RE: Request for Information #2 for File No. SUB21-002 – Angiuli Pacific Res Trust Short Subdivision
4001 West Mercer Way, Mercer Island, WA 98040;
King County Tax Parcel # 362350-0365

Please consider this as a written response to the City of Mercer Island second review comments dated March 17, 2022.

TEAM response

DWN BY DMT	DATE 2/8/2021	JOB NO. 17095
CHKD BY DMT	SCALE 1" = 20'	SHEET 3 OF 4

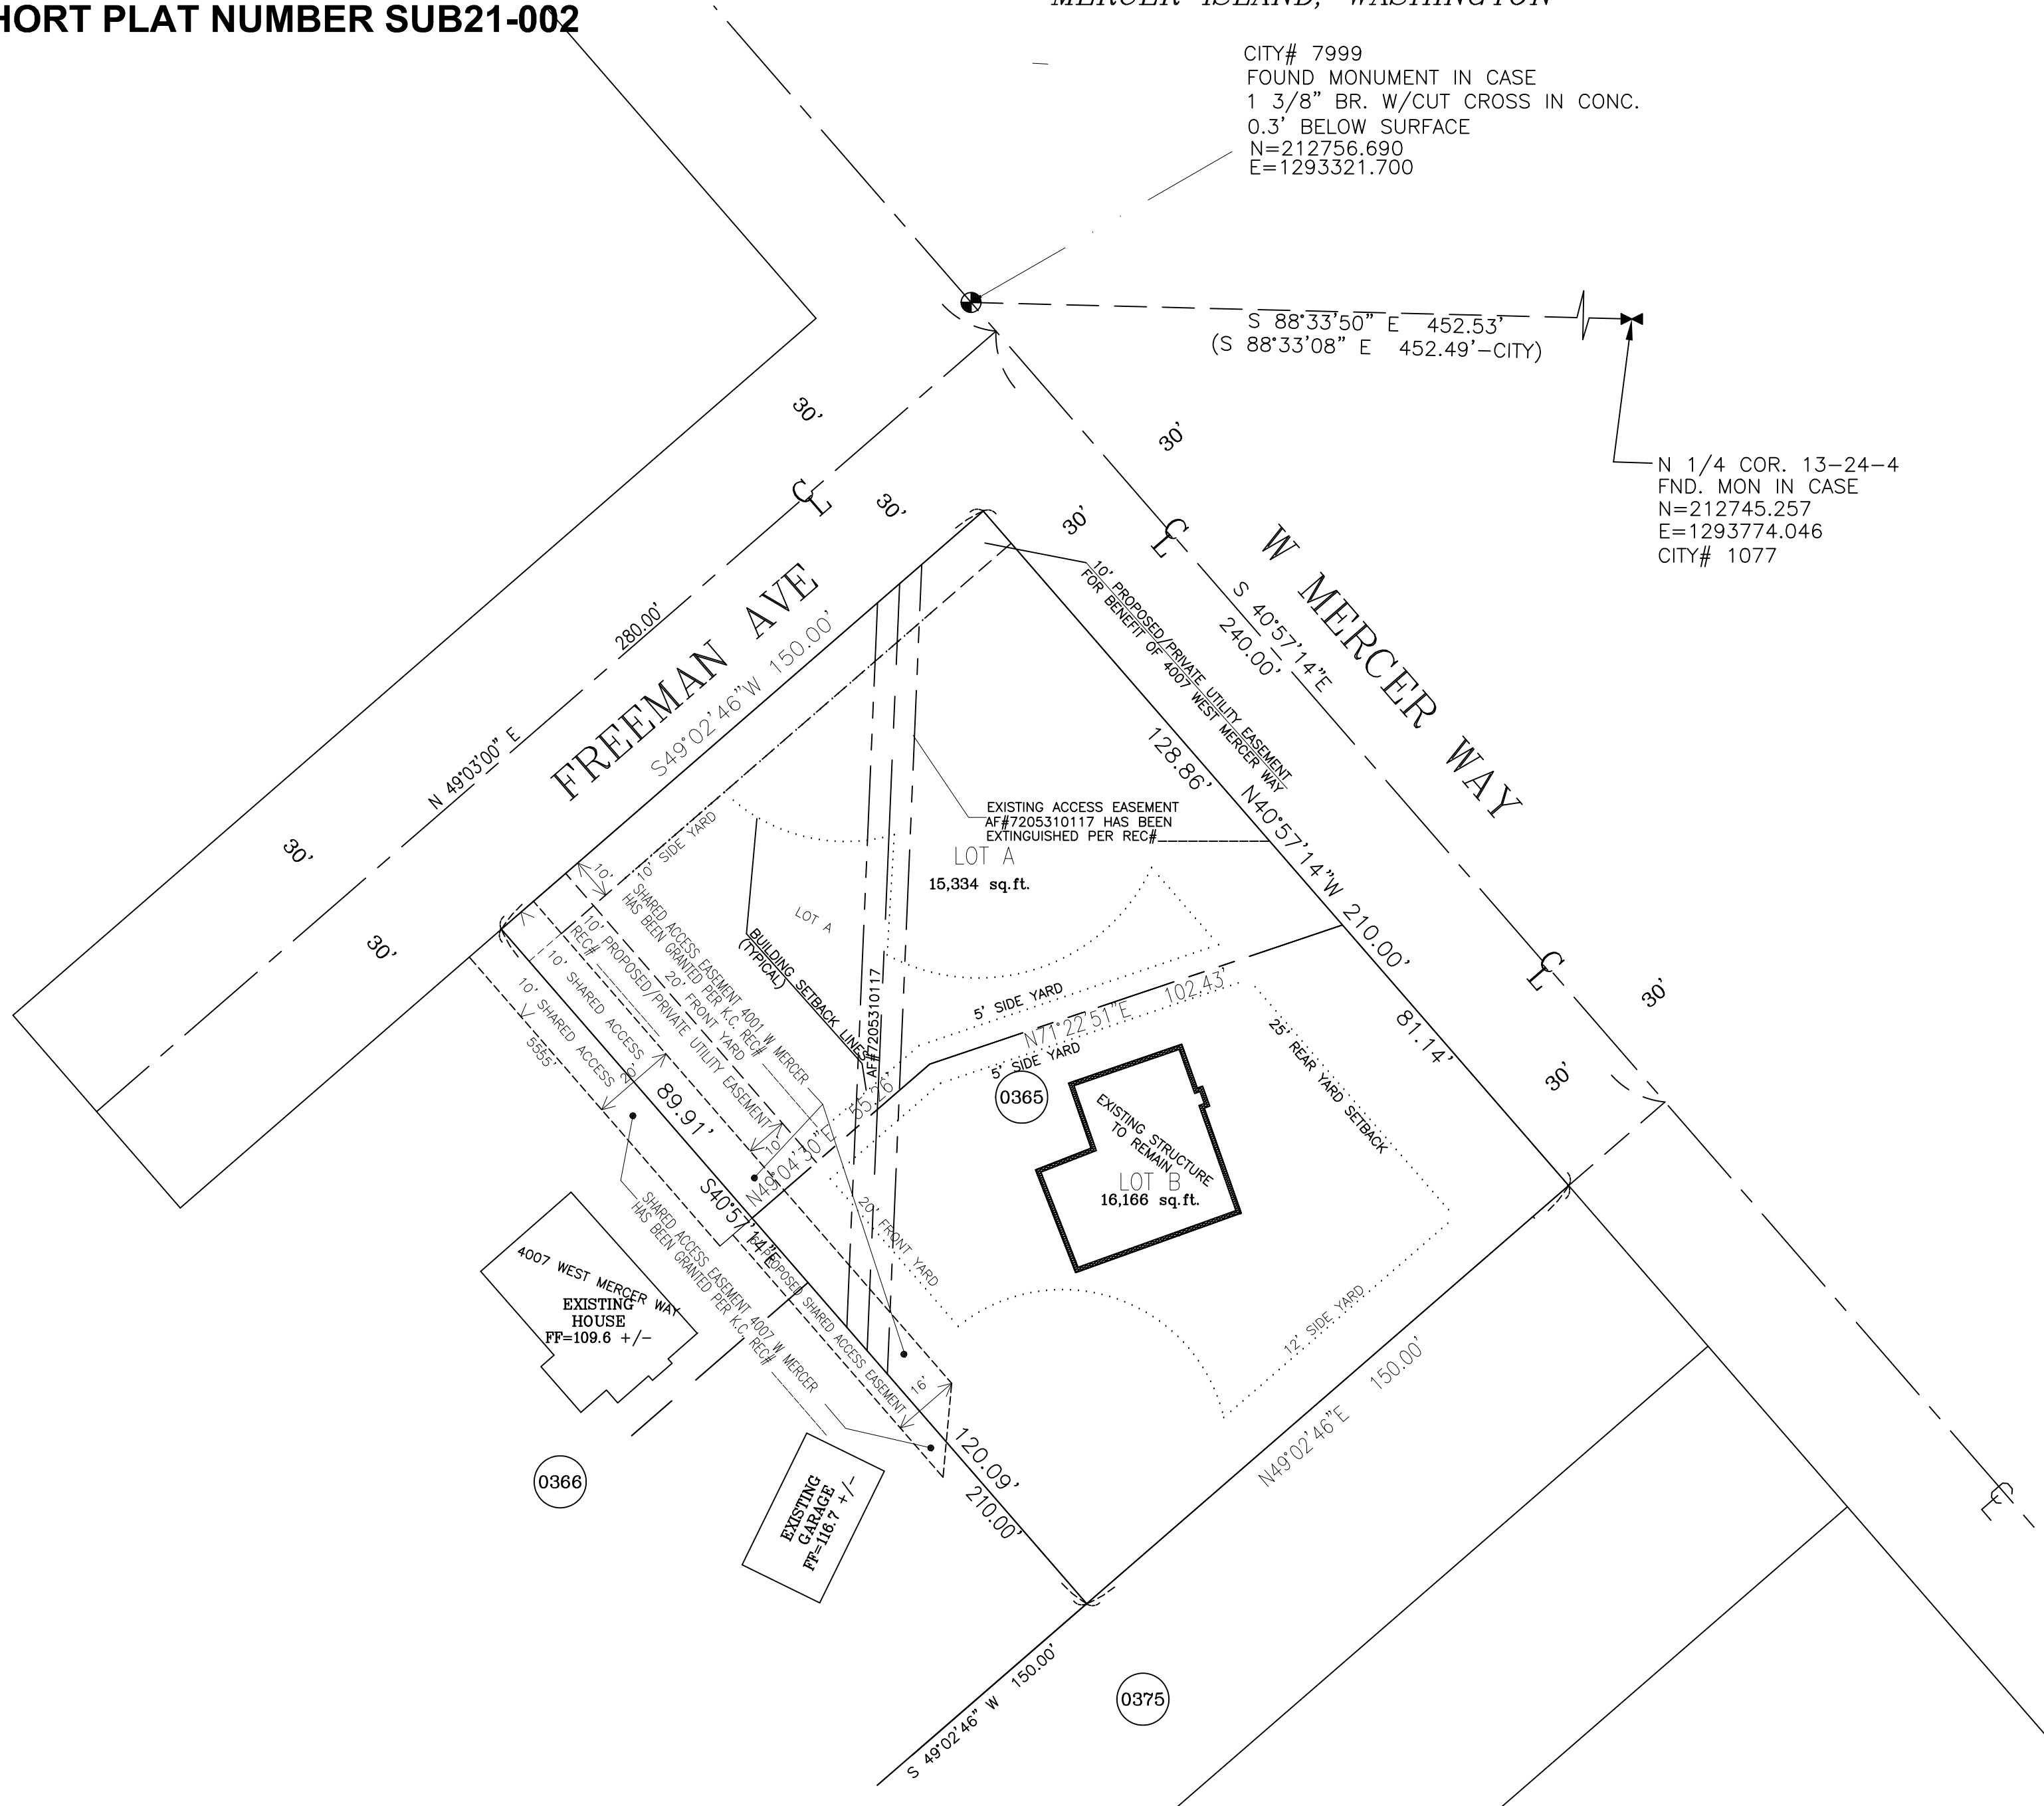
1. Extend the 20' access easement to the edge of the shared property line between Lot A and Lot B, as illustrated in the image to the right: **The access easement has been extended and shown on sheet 3 of 4 of the preliminary short plat and page 6 of 9 of the Development Plan Set.**

7. Refer to eplan review comments here:
 - a. Sheet 3 of 4 of Preliminary Short Plat
 - Clarify if existing access easement across 4001 will be extinguished as part of short plat or separate document? **The extinguishment of this access easement will be a separate document and will be extinguished before preliminary short plat. A note to this affect has been included on sheet 3 of 4 of the preliminary short plat map.**
 - Call out the ROW limits for Freeman Avenue. **The ROW limits have been shown on sheet 3 of 4 of the preliminary short plat map.**
 - b. Sheet 6 of 9 Development Plan Set
 - Is proposed access easement on 4007 part of short plat or separate document? **The granting of this access easement will be a separate document and recorded before preliminary short plat.**

SHEET  
6 OF 9

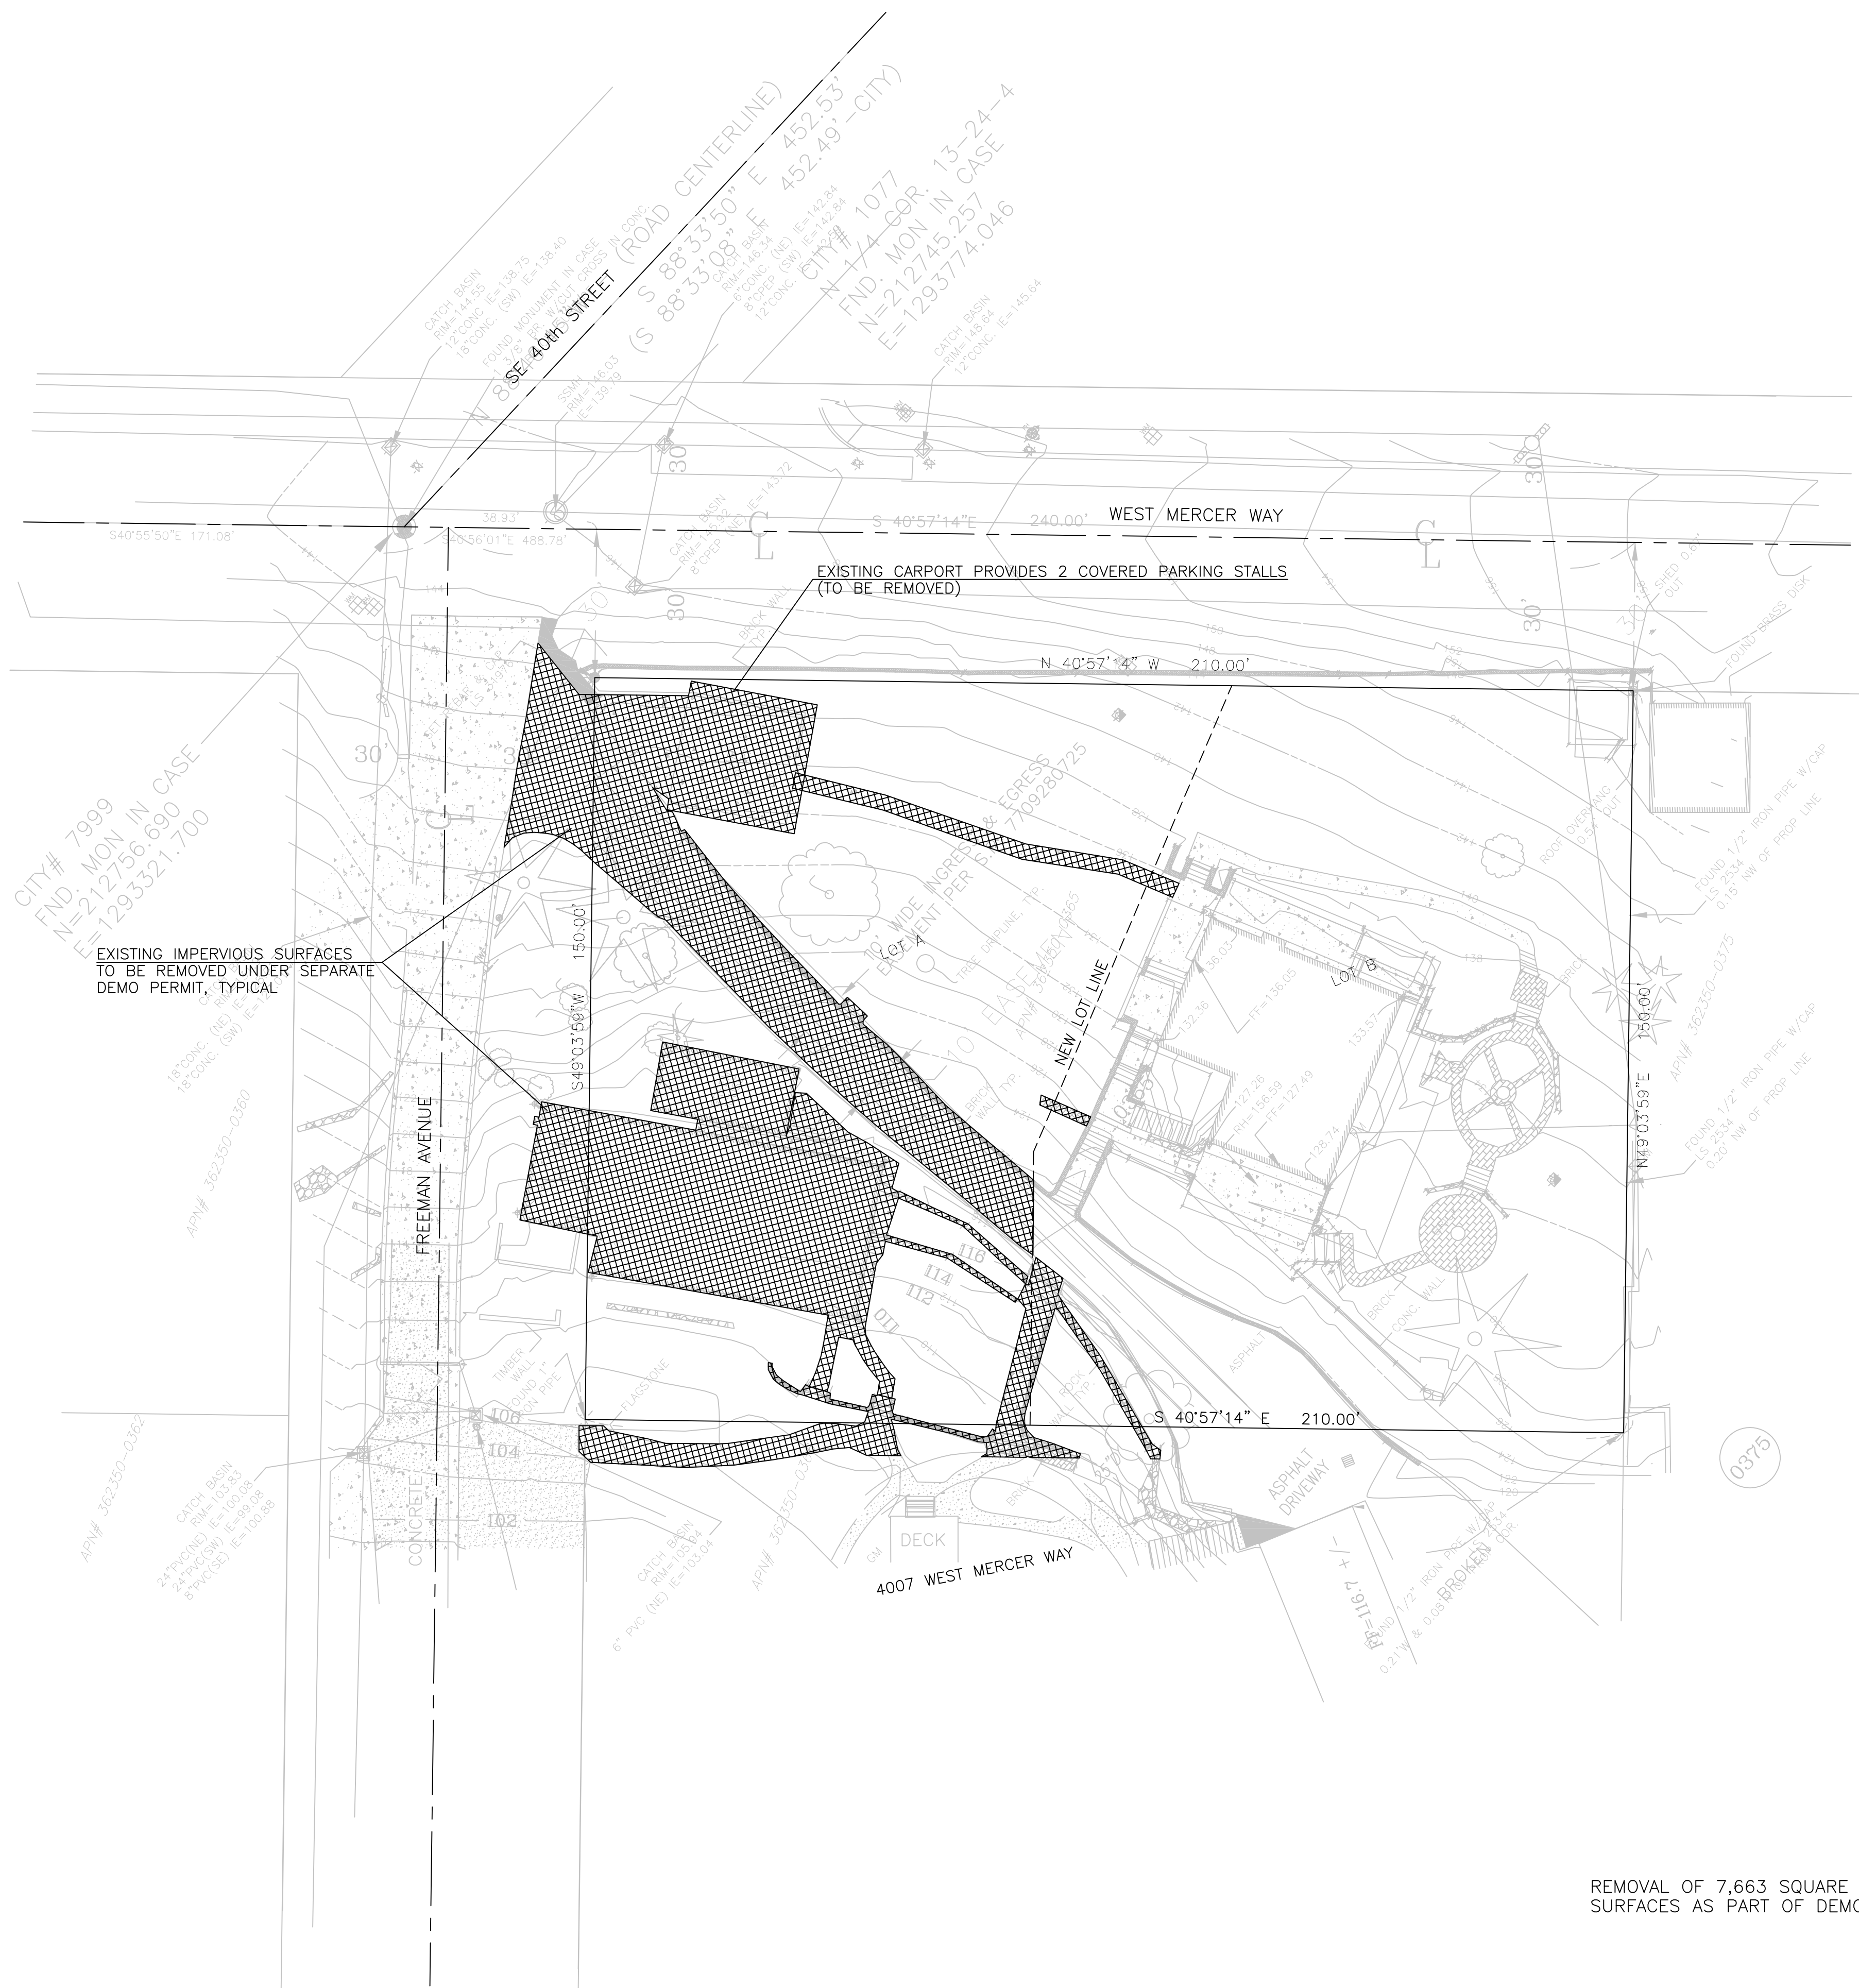
4. Building Pad:
 - a. In the applicant response letter, it was noted that the building pads were shown on sheet 6 of 9. Sheet 6 of 9, site plan, does not illustrate and label the two (2) building pad areas. Building pad area is different from proposed building footprint. Please refer to Attachment A Building Pad Examples. **The Building Pad Areas are shown on Sheet 6 of 9 of the Development Plan Set.**

5. General:
 - a. As requested by Fire, a portion of the proposed 20' access easement on 4007 West Mercer Way will be expanded which will impact net lot area. On sheet 6 of 9 please revise the net lot area for the "new 4007 West Mercer Way." **The net lot area for 4007 has been revised on Sheet 6 of 9 of the Development Plan Set.**

preliminary plat approval will be that a note shall be added to the plat stating the following: "Lot A driveway placement shall be constructed as shown on sheet 6 of 9." **Noted, we understand this will be a condition of approval.**
